Water & Sanitation District No. 1

June 15, 2017

RE: The Beach at Woodmoor PUD/Preliminary Plan (PUDSP-17-003)
Residential Subdivision Planning Documents (6 sheets) REVIEW 1

The Beach at Lake Woodmoor
Utility System Plan
El Paso County, Colorado

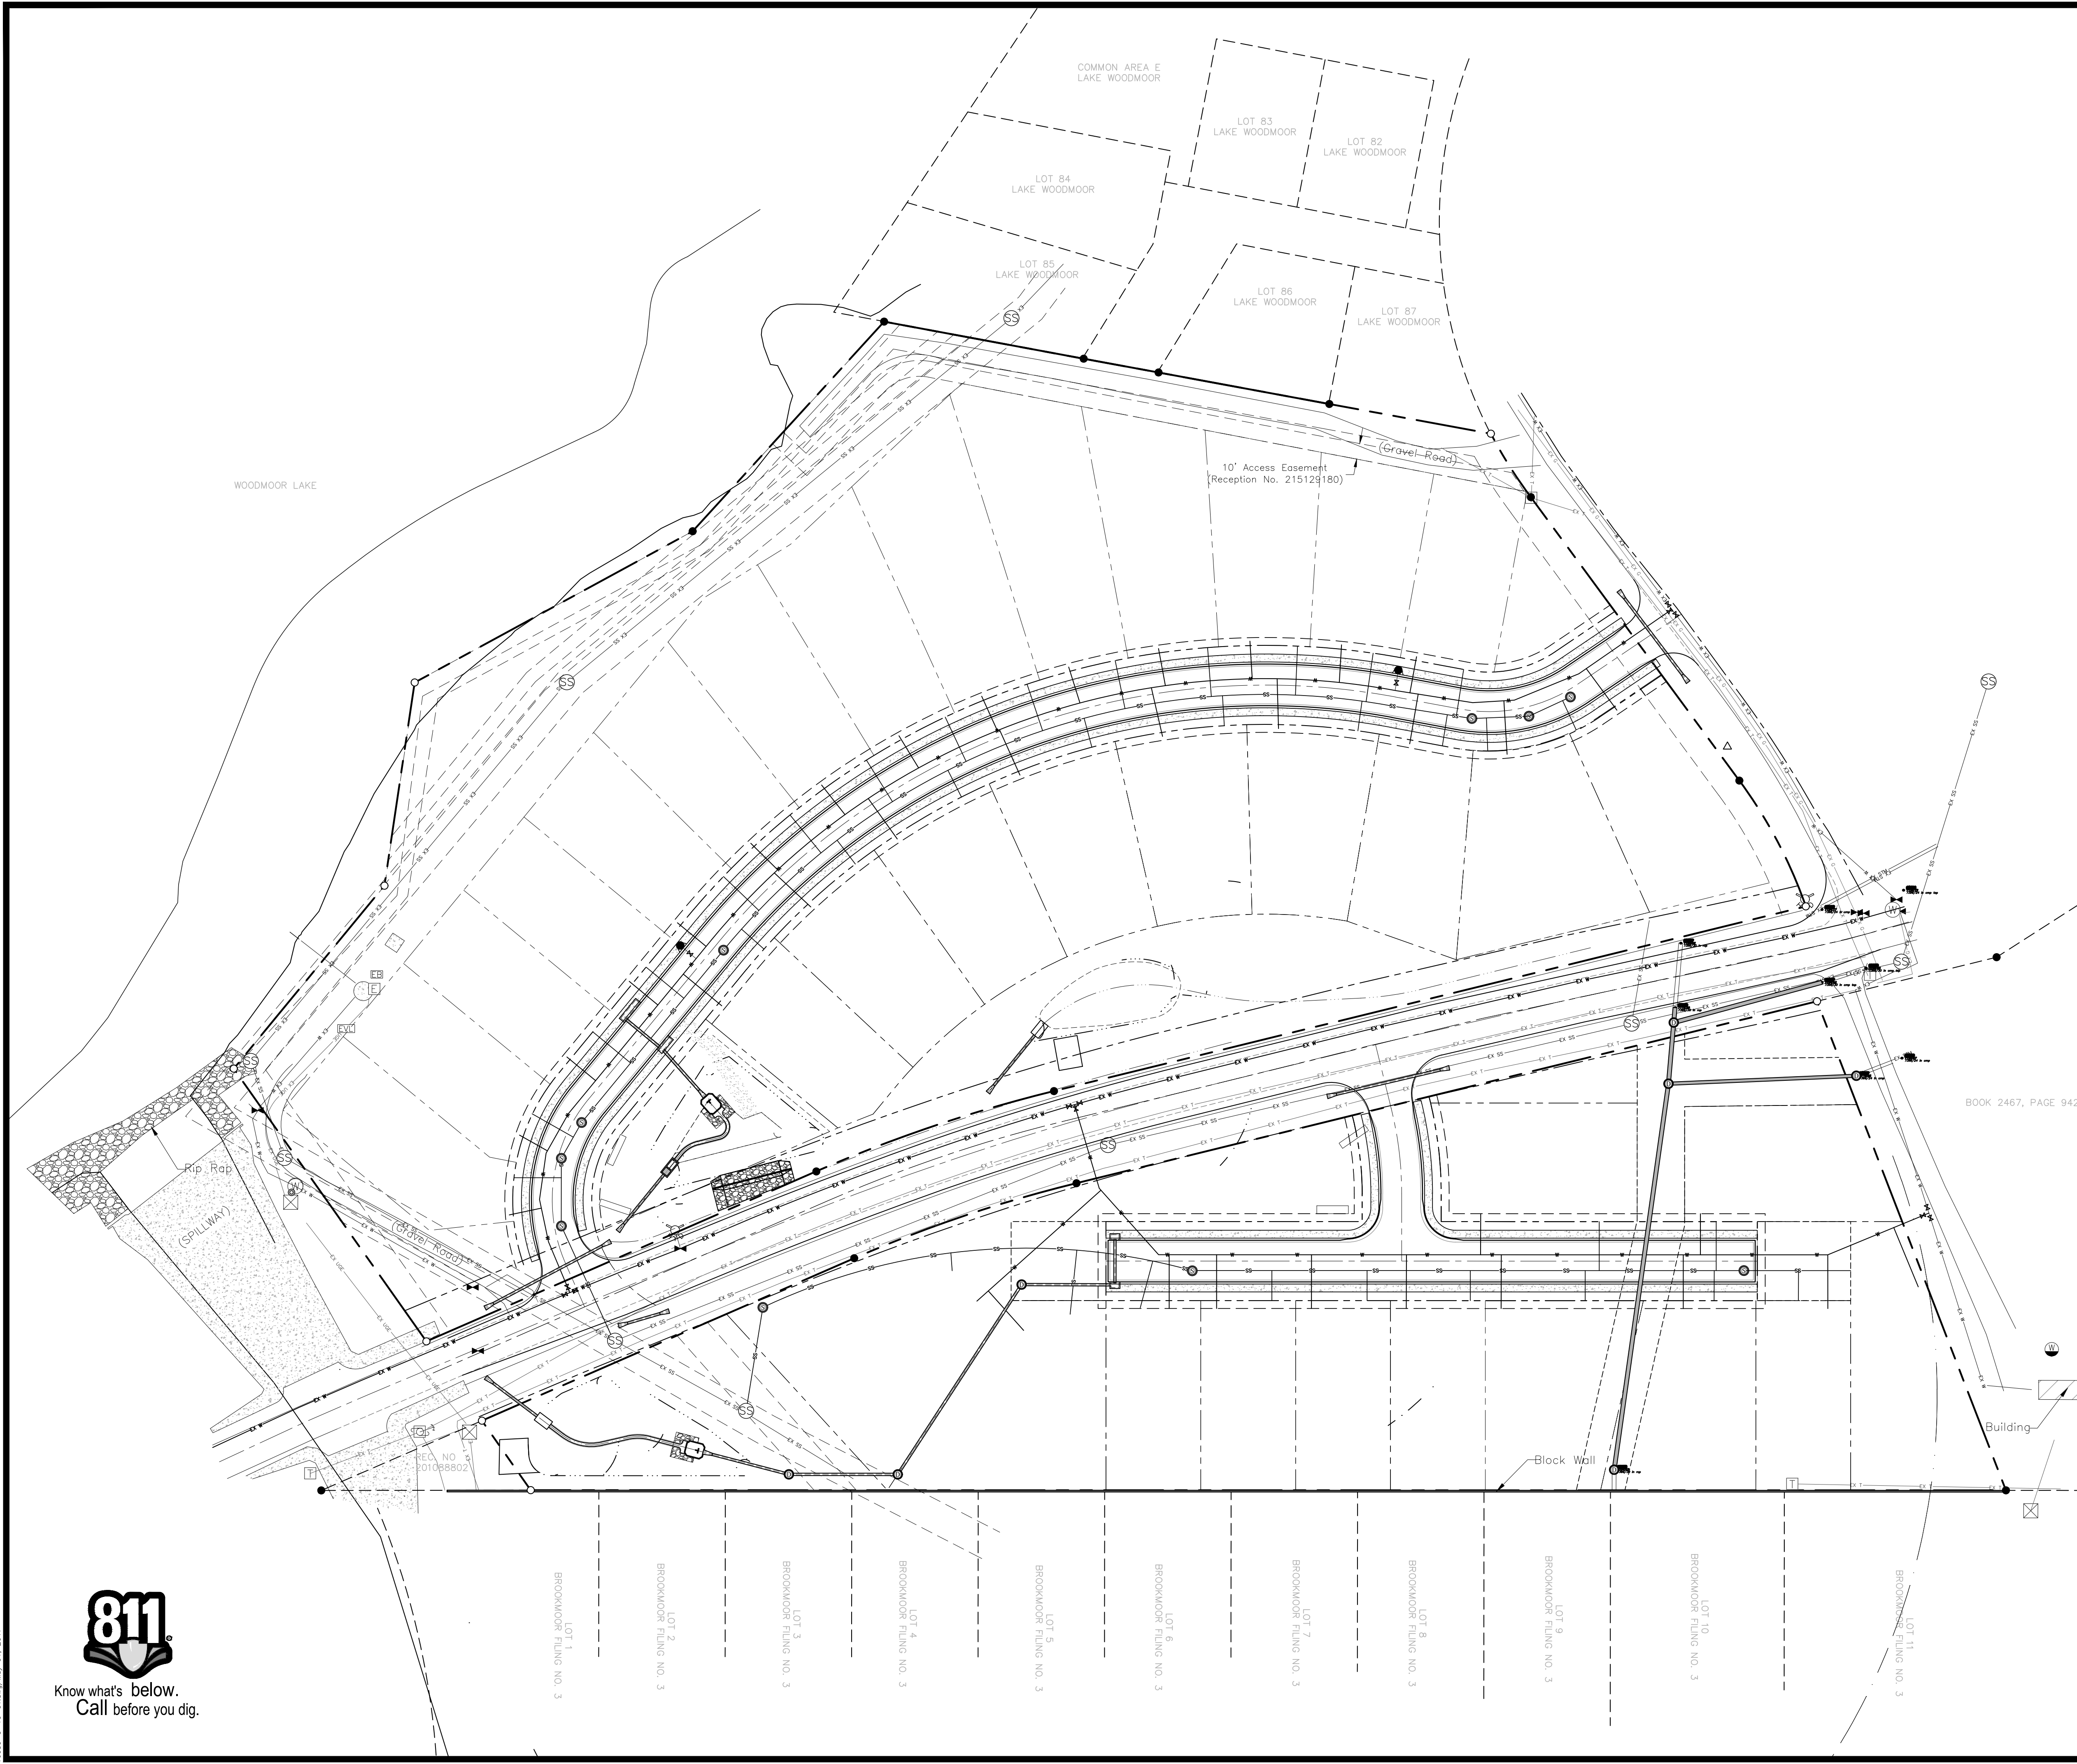
1. The curvilinear sanitary sewer line from Captiva Beach Lane across Lot 35 violates the District's system specifications because it is non-tangential. As possible, the District avoids curvilinear sewer lines and an easement twice as wide as the main is deep would be required around the proposed route. Please note the alternative route the District proposes, in accordance with our system requirements, between Lot 33 and 34 with easement (not to scale) for the District depicted on the attached marked drawing.
2. There are no fire hydrants shown south of Lake Woodmoor Drive along Captiva Beach Lane. Please consult the applicable fire department with jurisdiction over

this development regarding spacing and location of fire hydrants and add hydrant locations to plan.

3. The District requires a minimum of 6 feet of cover for all mains measured from the finished grade to the top of the main. Please confirm the grading plan for Tract H maintains this minimum cover requirement for the existing sewer main in this proposed lot.

4. The District is concerned about adding a fourth connection from the northwest to the manhole in Lake Woodmoor Drive. Please terminate proposed Coronado Beach Drive sanitary sewer main on north side of Lake Woodmoor Drive. Reference the attached marked drawing.

5. Manholes are required at minimum every 500 linear feet for sewer mains per the District's system specifications. Please ensure this requirement is met along Coronado Beach Drive.

6. Riprock (End FES) at STA 10+00 North of Tract H interferes with the existing sanitary sewer manhole risking storm water infiltration to the District's sewer infrastructure. Developer's engineer will need to evaluate relocating riprock or relocation of existing sanitary sewer manhole.

1. As shown on the Utility System Plan, Tract H encroaches upon the District's Parcel #14100015. Use of District property required Board approval. Please revise plans or obtain Board approval prior to plan approval.
2. Please clarify the boundaries of Parcels A & B.
